City of Portland, Maine – Building or Use Permit Application 389 Congress Street, 04101, Tel: (207) 874-8703, FAX: 874-8716

Location of Construction: 42 Wells St		Owner: Abbott, Edward & Linda		Phone: #799-7768 874-8941 w	Permit No 980354 PERMIT ISSUED Permit Issued: APR 13 1998 CITY OF PORTLAND Zone: 158 CBL: 041-1-017 Zoning Approval: OK Special Zone or Reviews: <input type="checkbox"/> Shoreland <input type="checkbox"/> Wetland <input type="checkbox"/> Flood Zone <input type="checkbox"/> Subdivision <input type="checkbox"/> Site Plan maj <input type="checkbox"/> minor <input type="checkbox"/> mm <input type="checkbox"/>	
Owner Address: 107 Main St. So. Portland		Lessee/Buyer's Name: d, ne 14116		Phone:		BusinessName:
Contractor Name: M. J. ...		Address: ...		Phone:		
Past Use:	Proposed Use:	COST OF WORK: \$ 1,500.00	PERMIT FEE: 30.00 \$ 2125.00	INSPECTION: Use Group# Type: 158		
Proposed Project Description: New Fire Escape installed Add door/second floor door to second floor escape		FIRE DEPT. <input checked="" type="checkbox"/> Approved <input type="checkbox"/> Denied Signature: <i>[Signature]</i>		PEDESTRIAN ACTIVITIES DISTRICT (P.A.D.) Action: <input type="checkbox"/> Appro

FIRE ESCAPE FOR 42 MELLEW ST.
" ALL PRESSURE TREATED LUMBER"

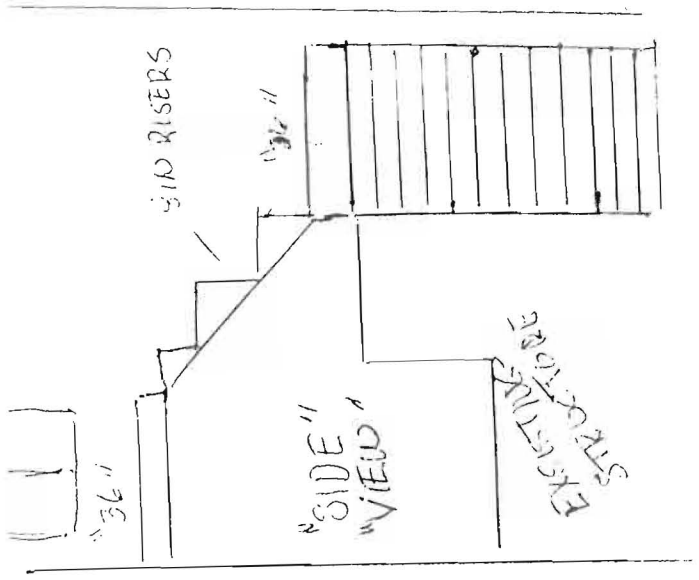
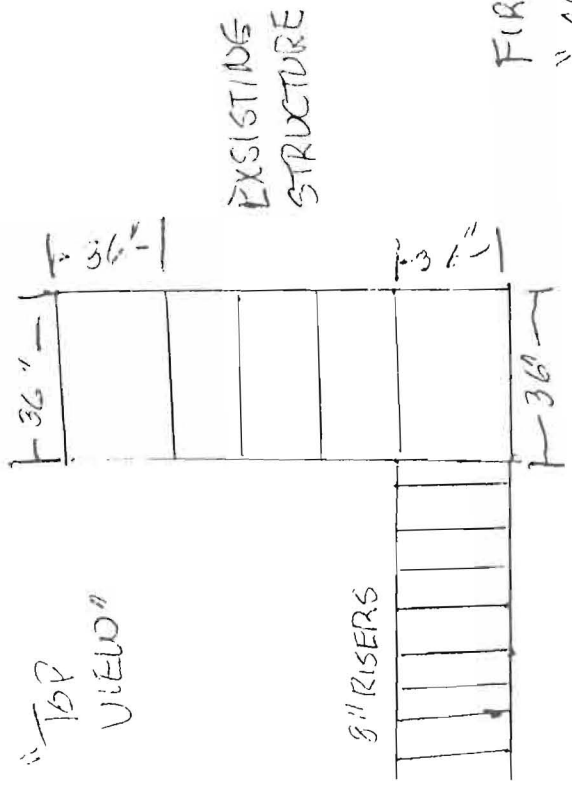
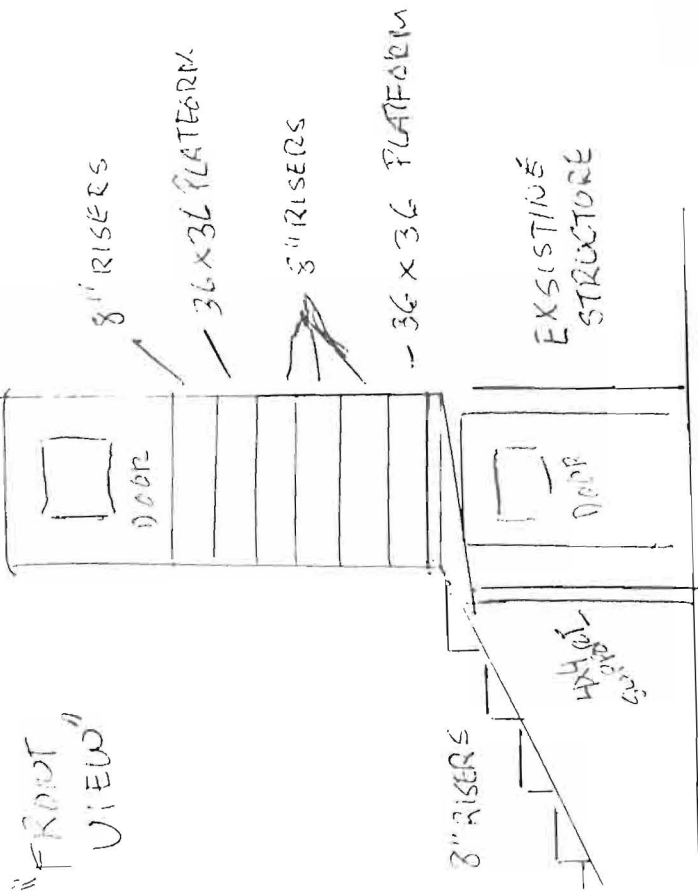
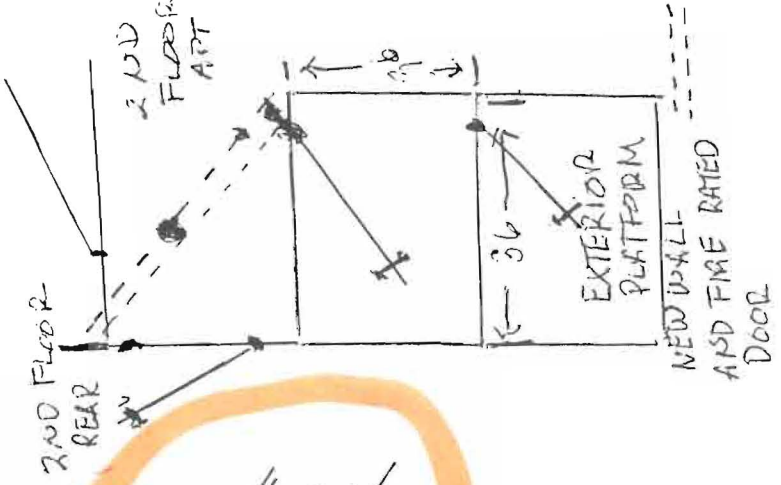
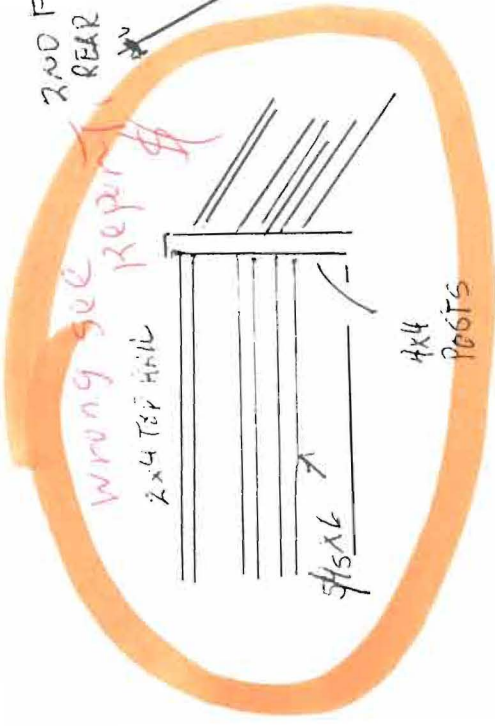
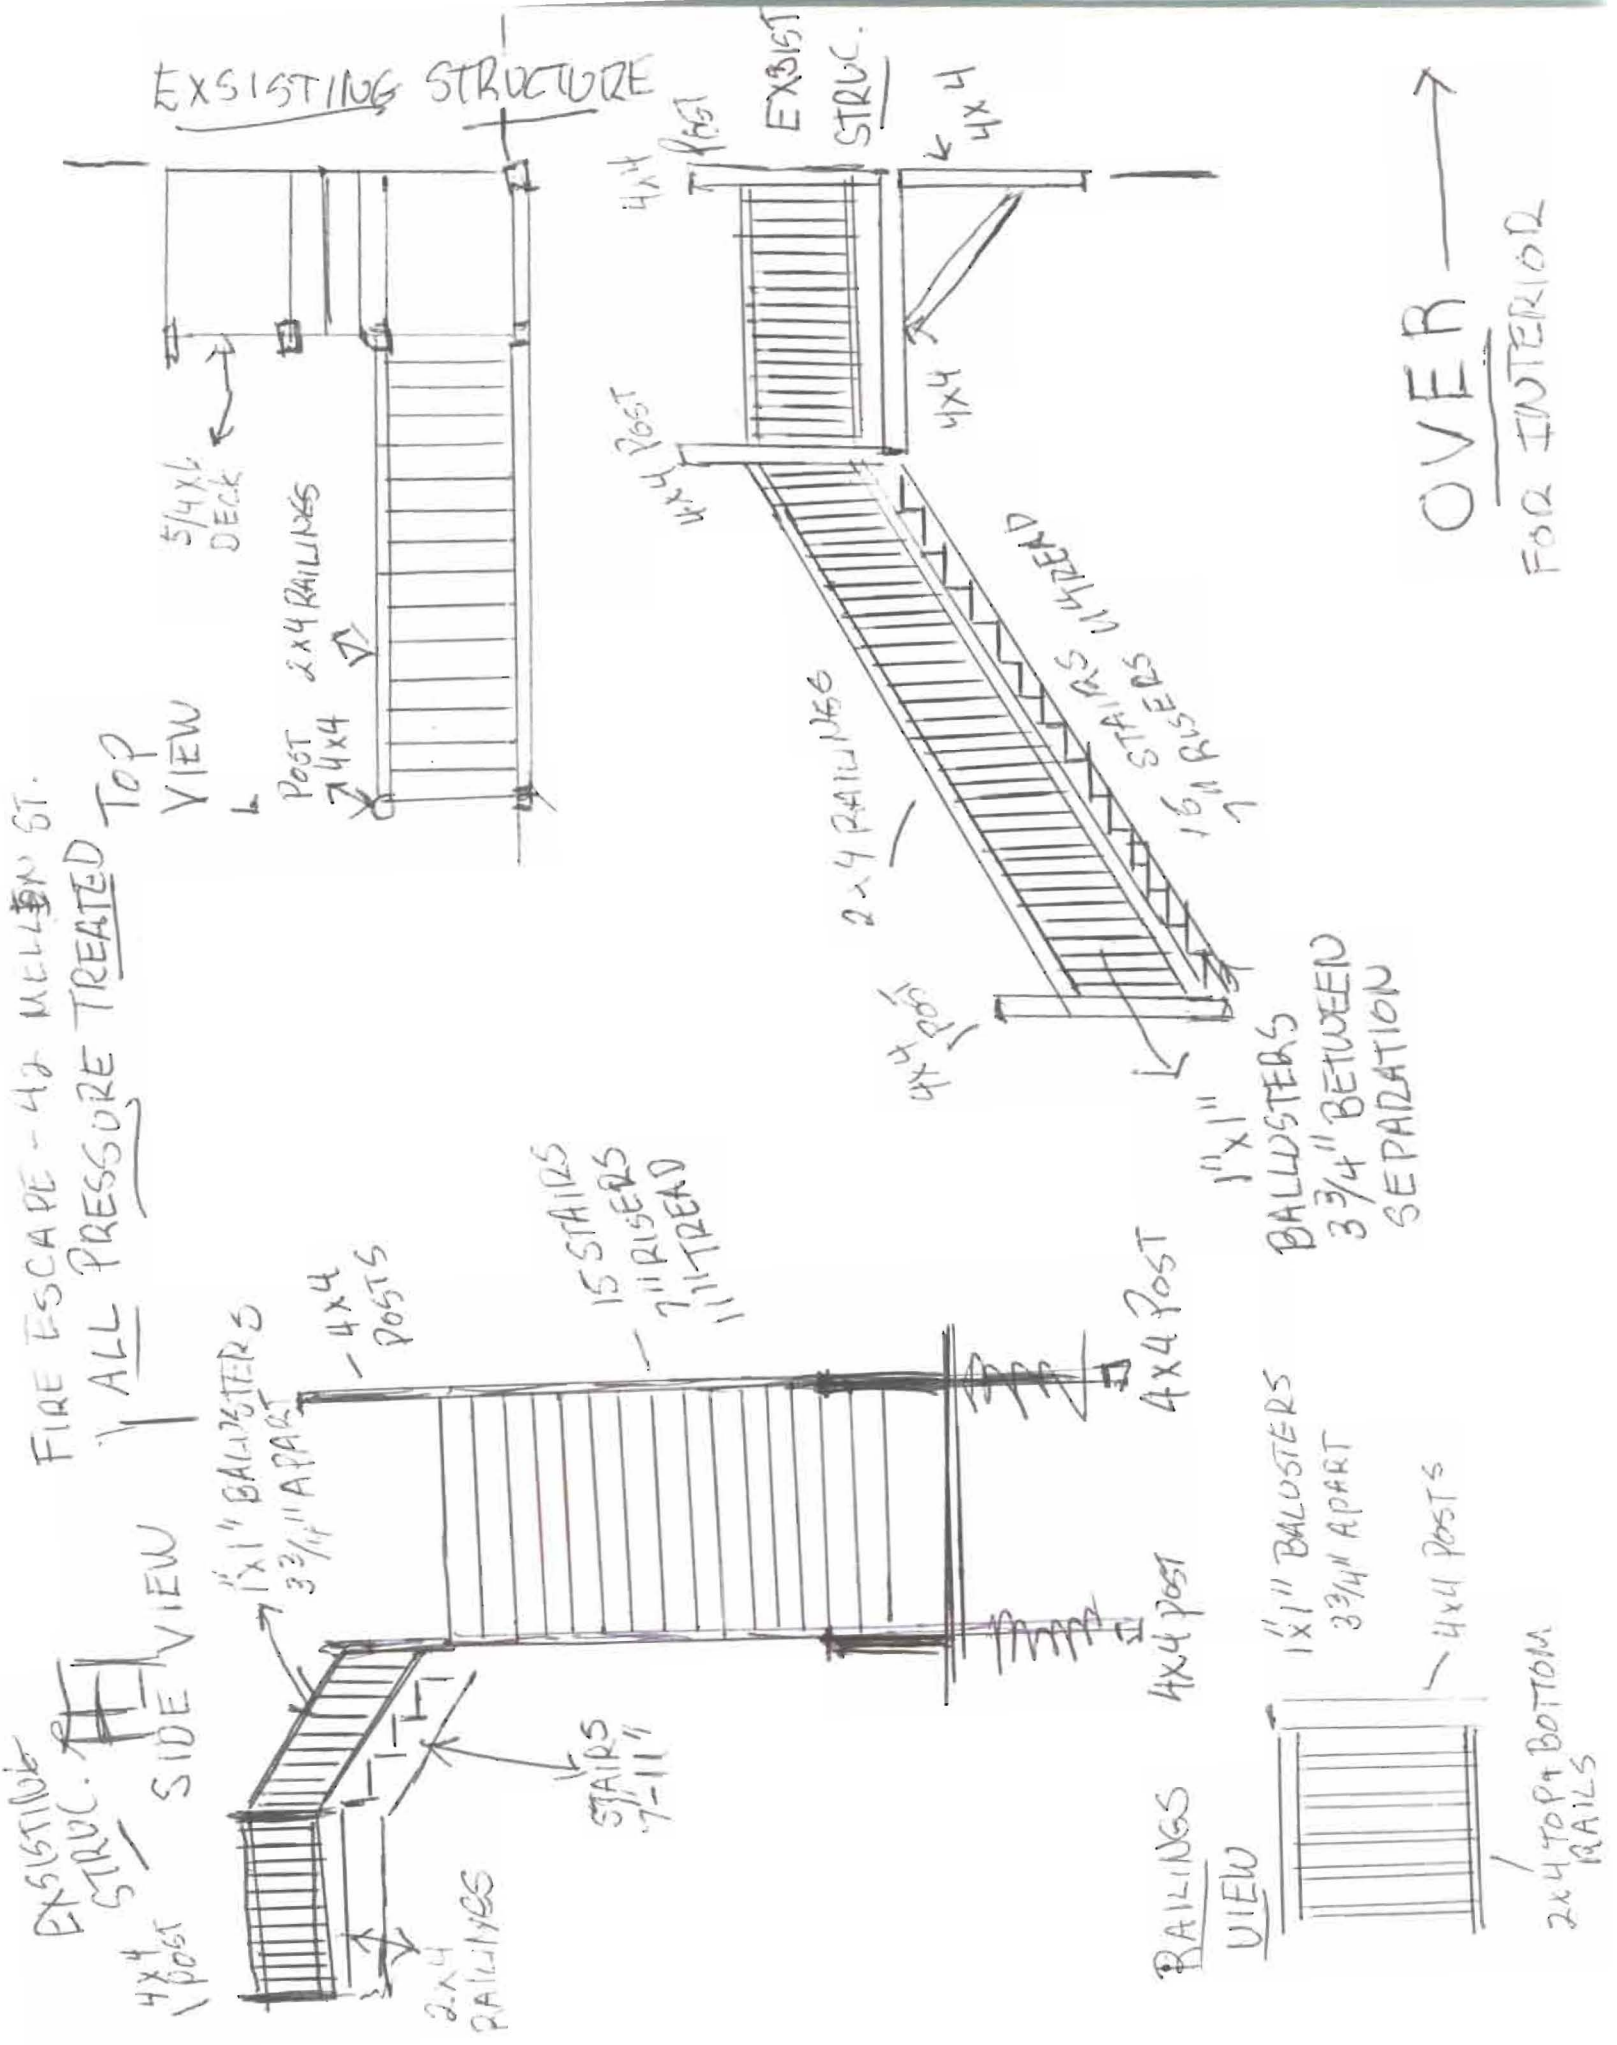
39 3/4" High.
A

4-22-98 Does not meet Height Requirement of 42" Guard Rails No Risers on Stairs
No Light over Stairs, Does not meet condition of approval, First ascent of Stairs
Railings 27 3/8" apart, hand Rail made From 2" x 4" - 3 1/2" wide?
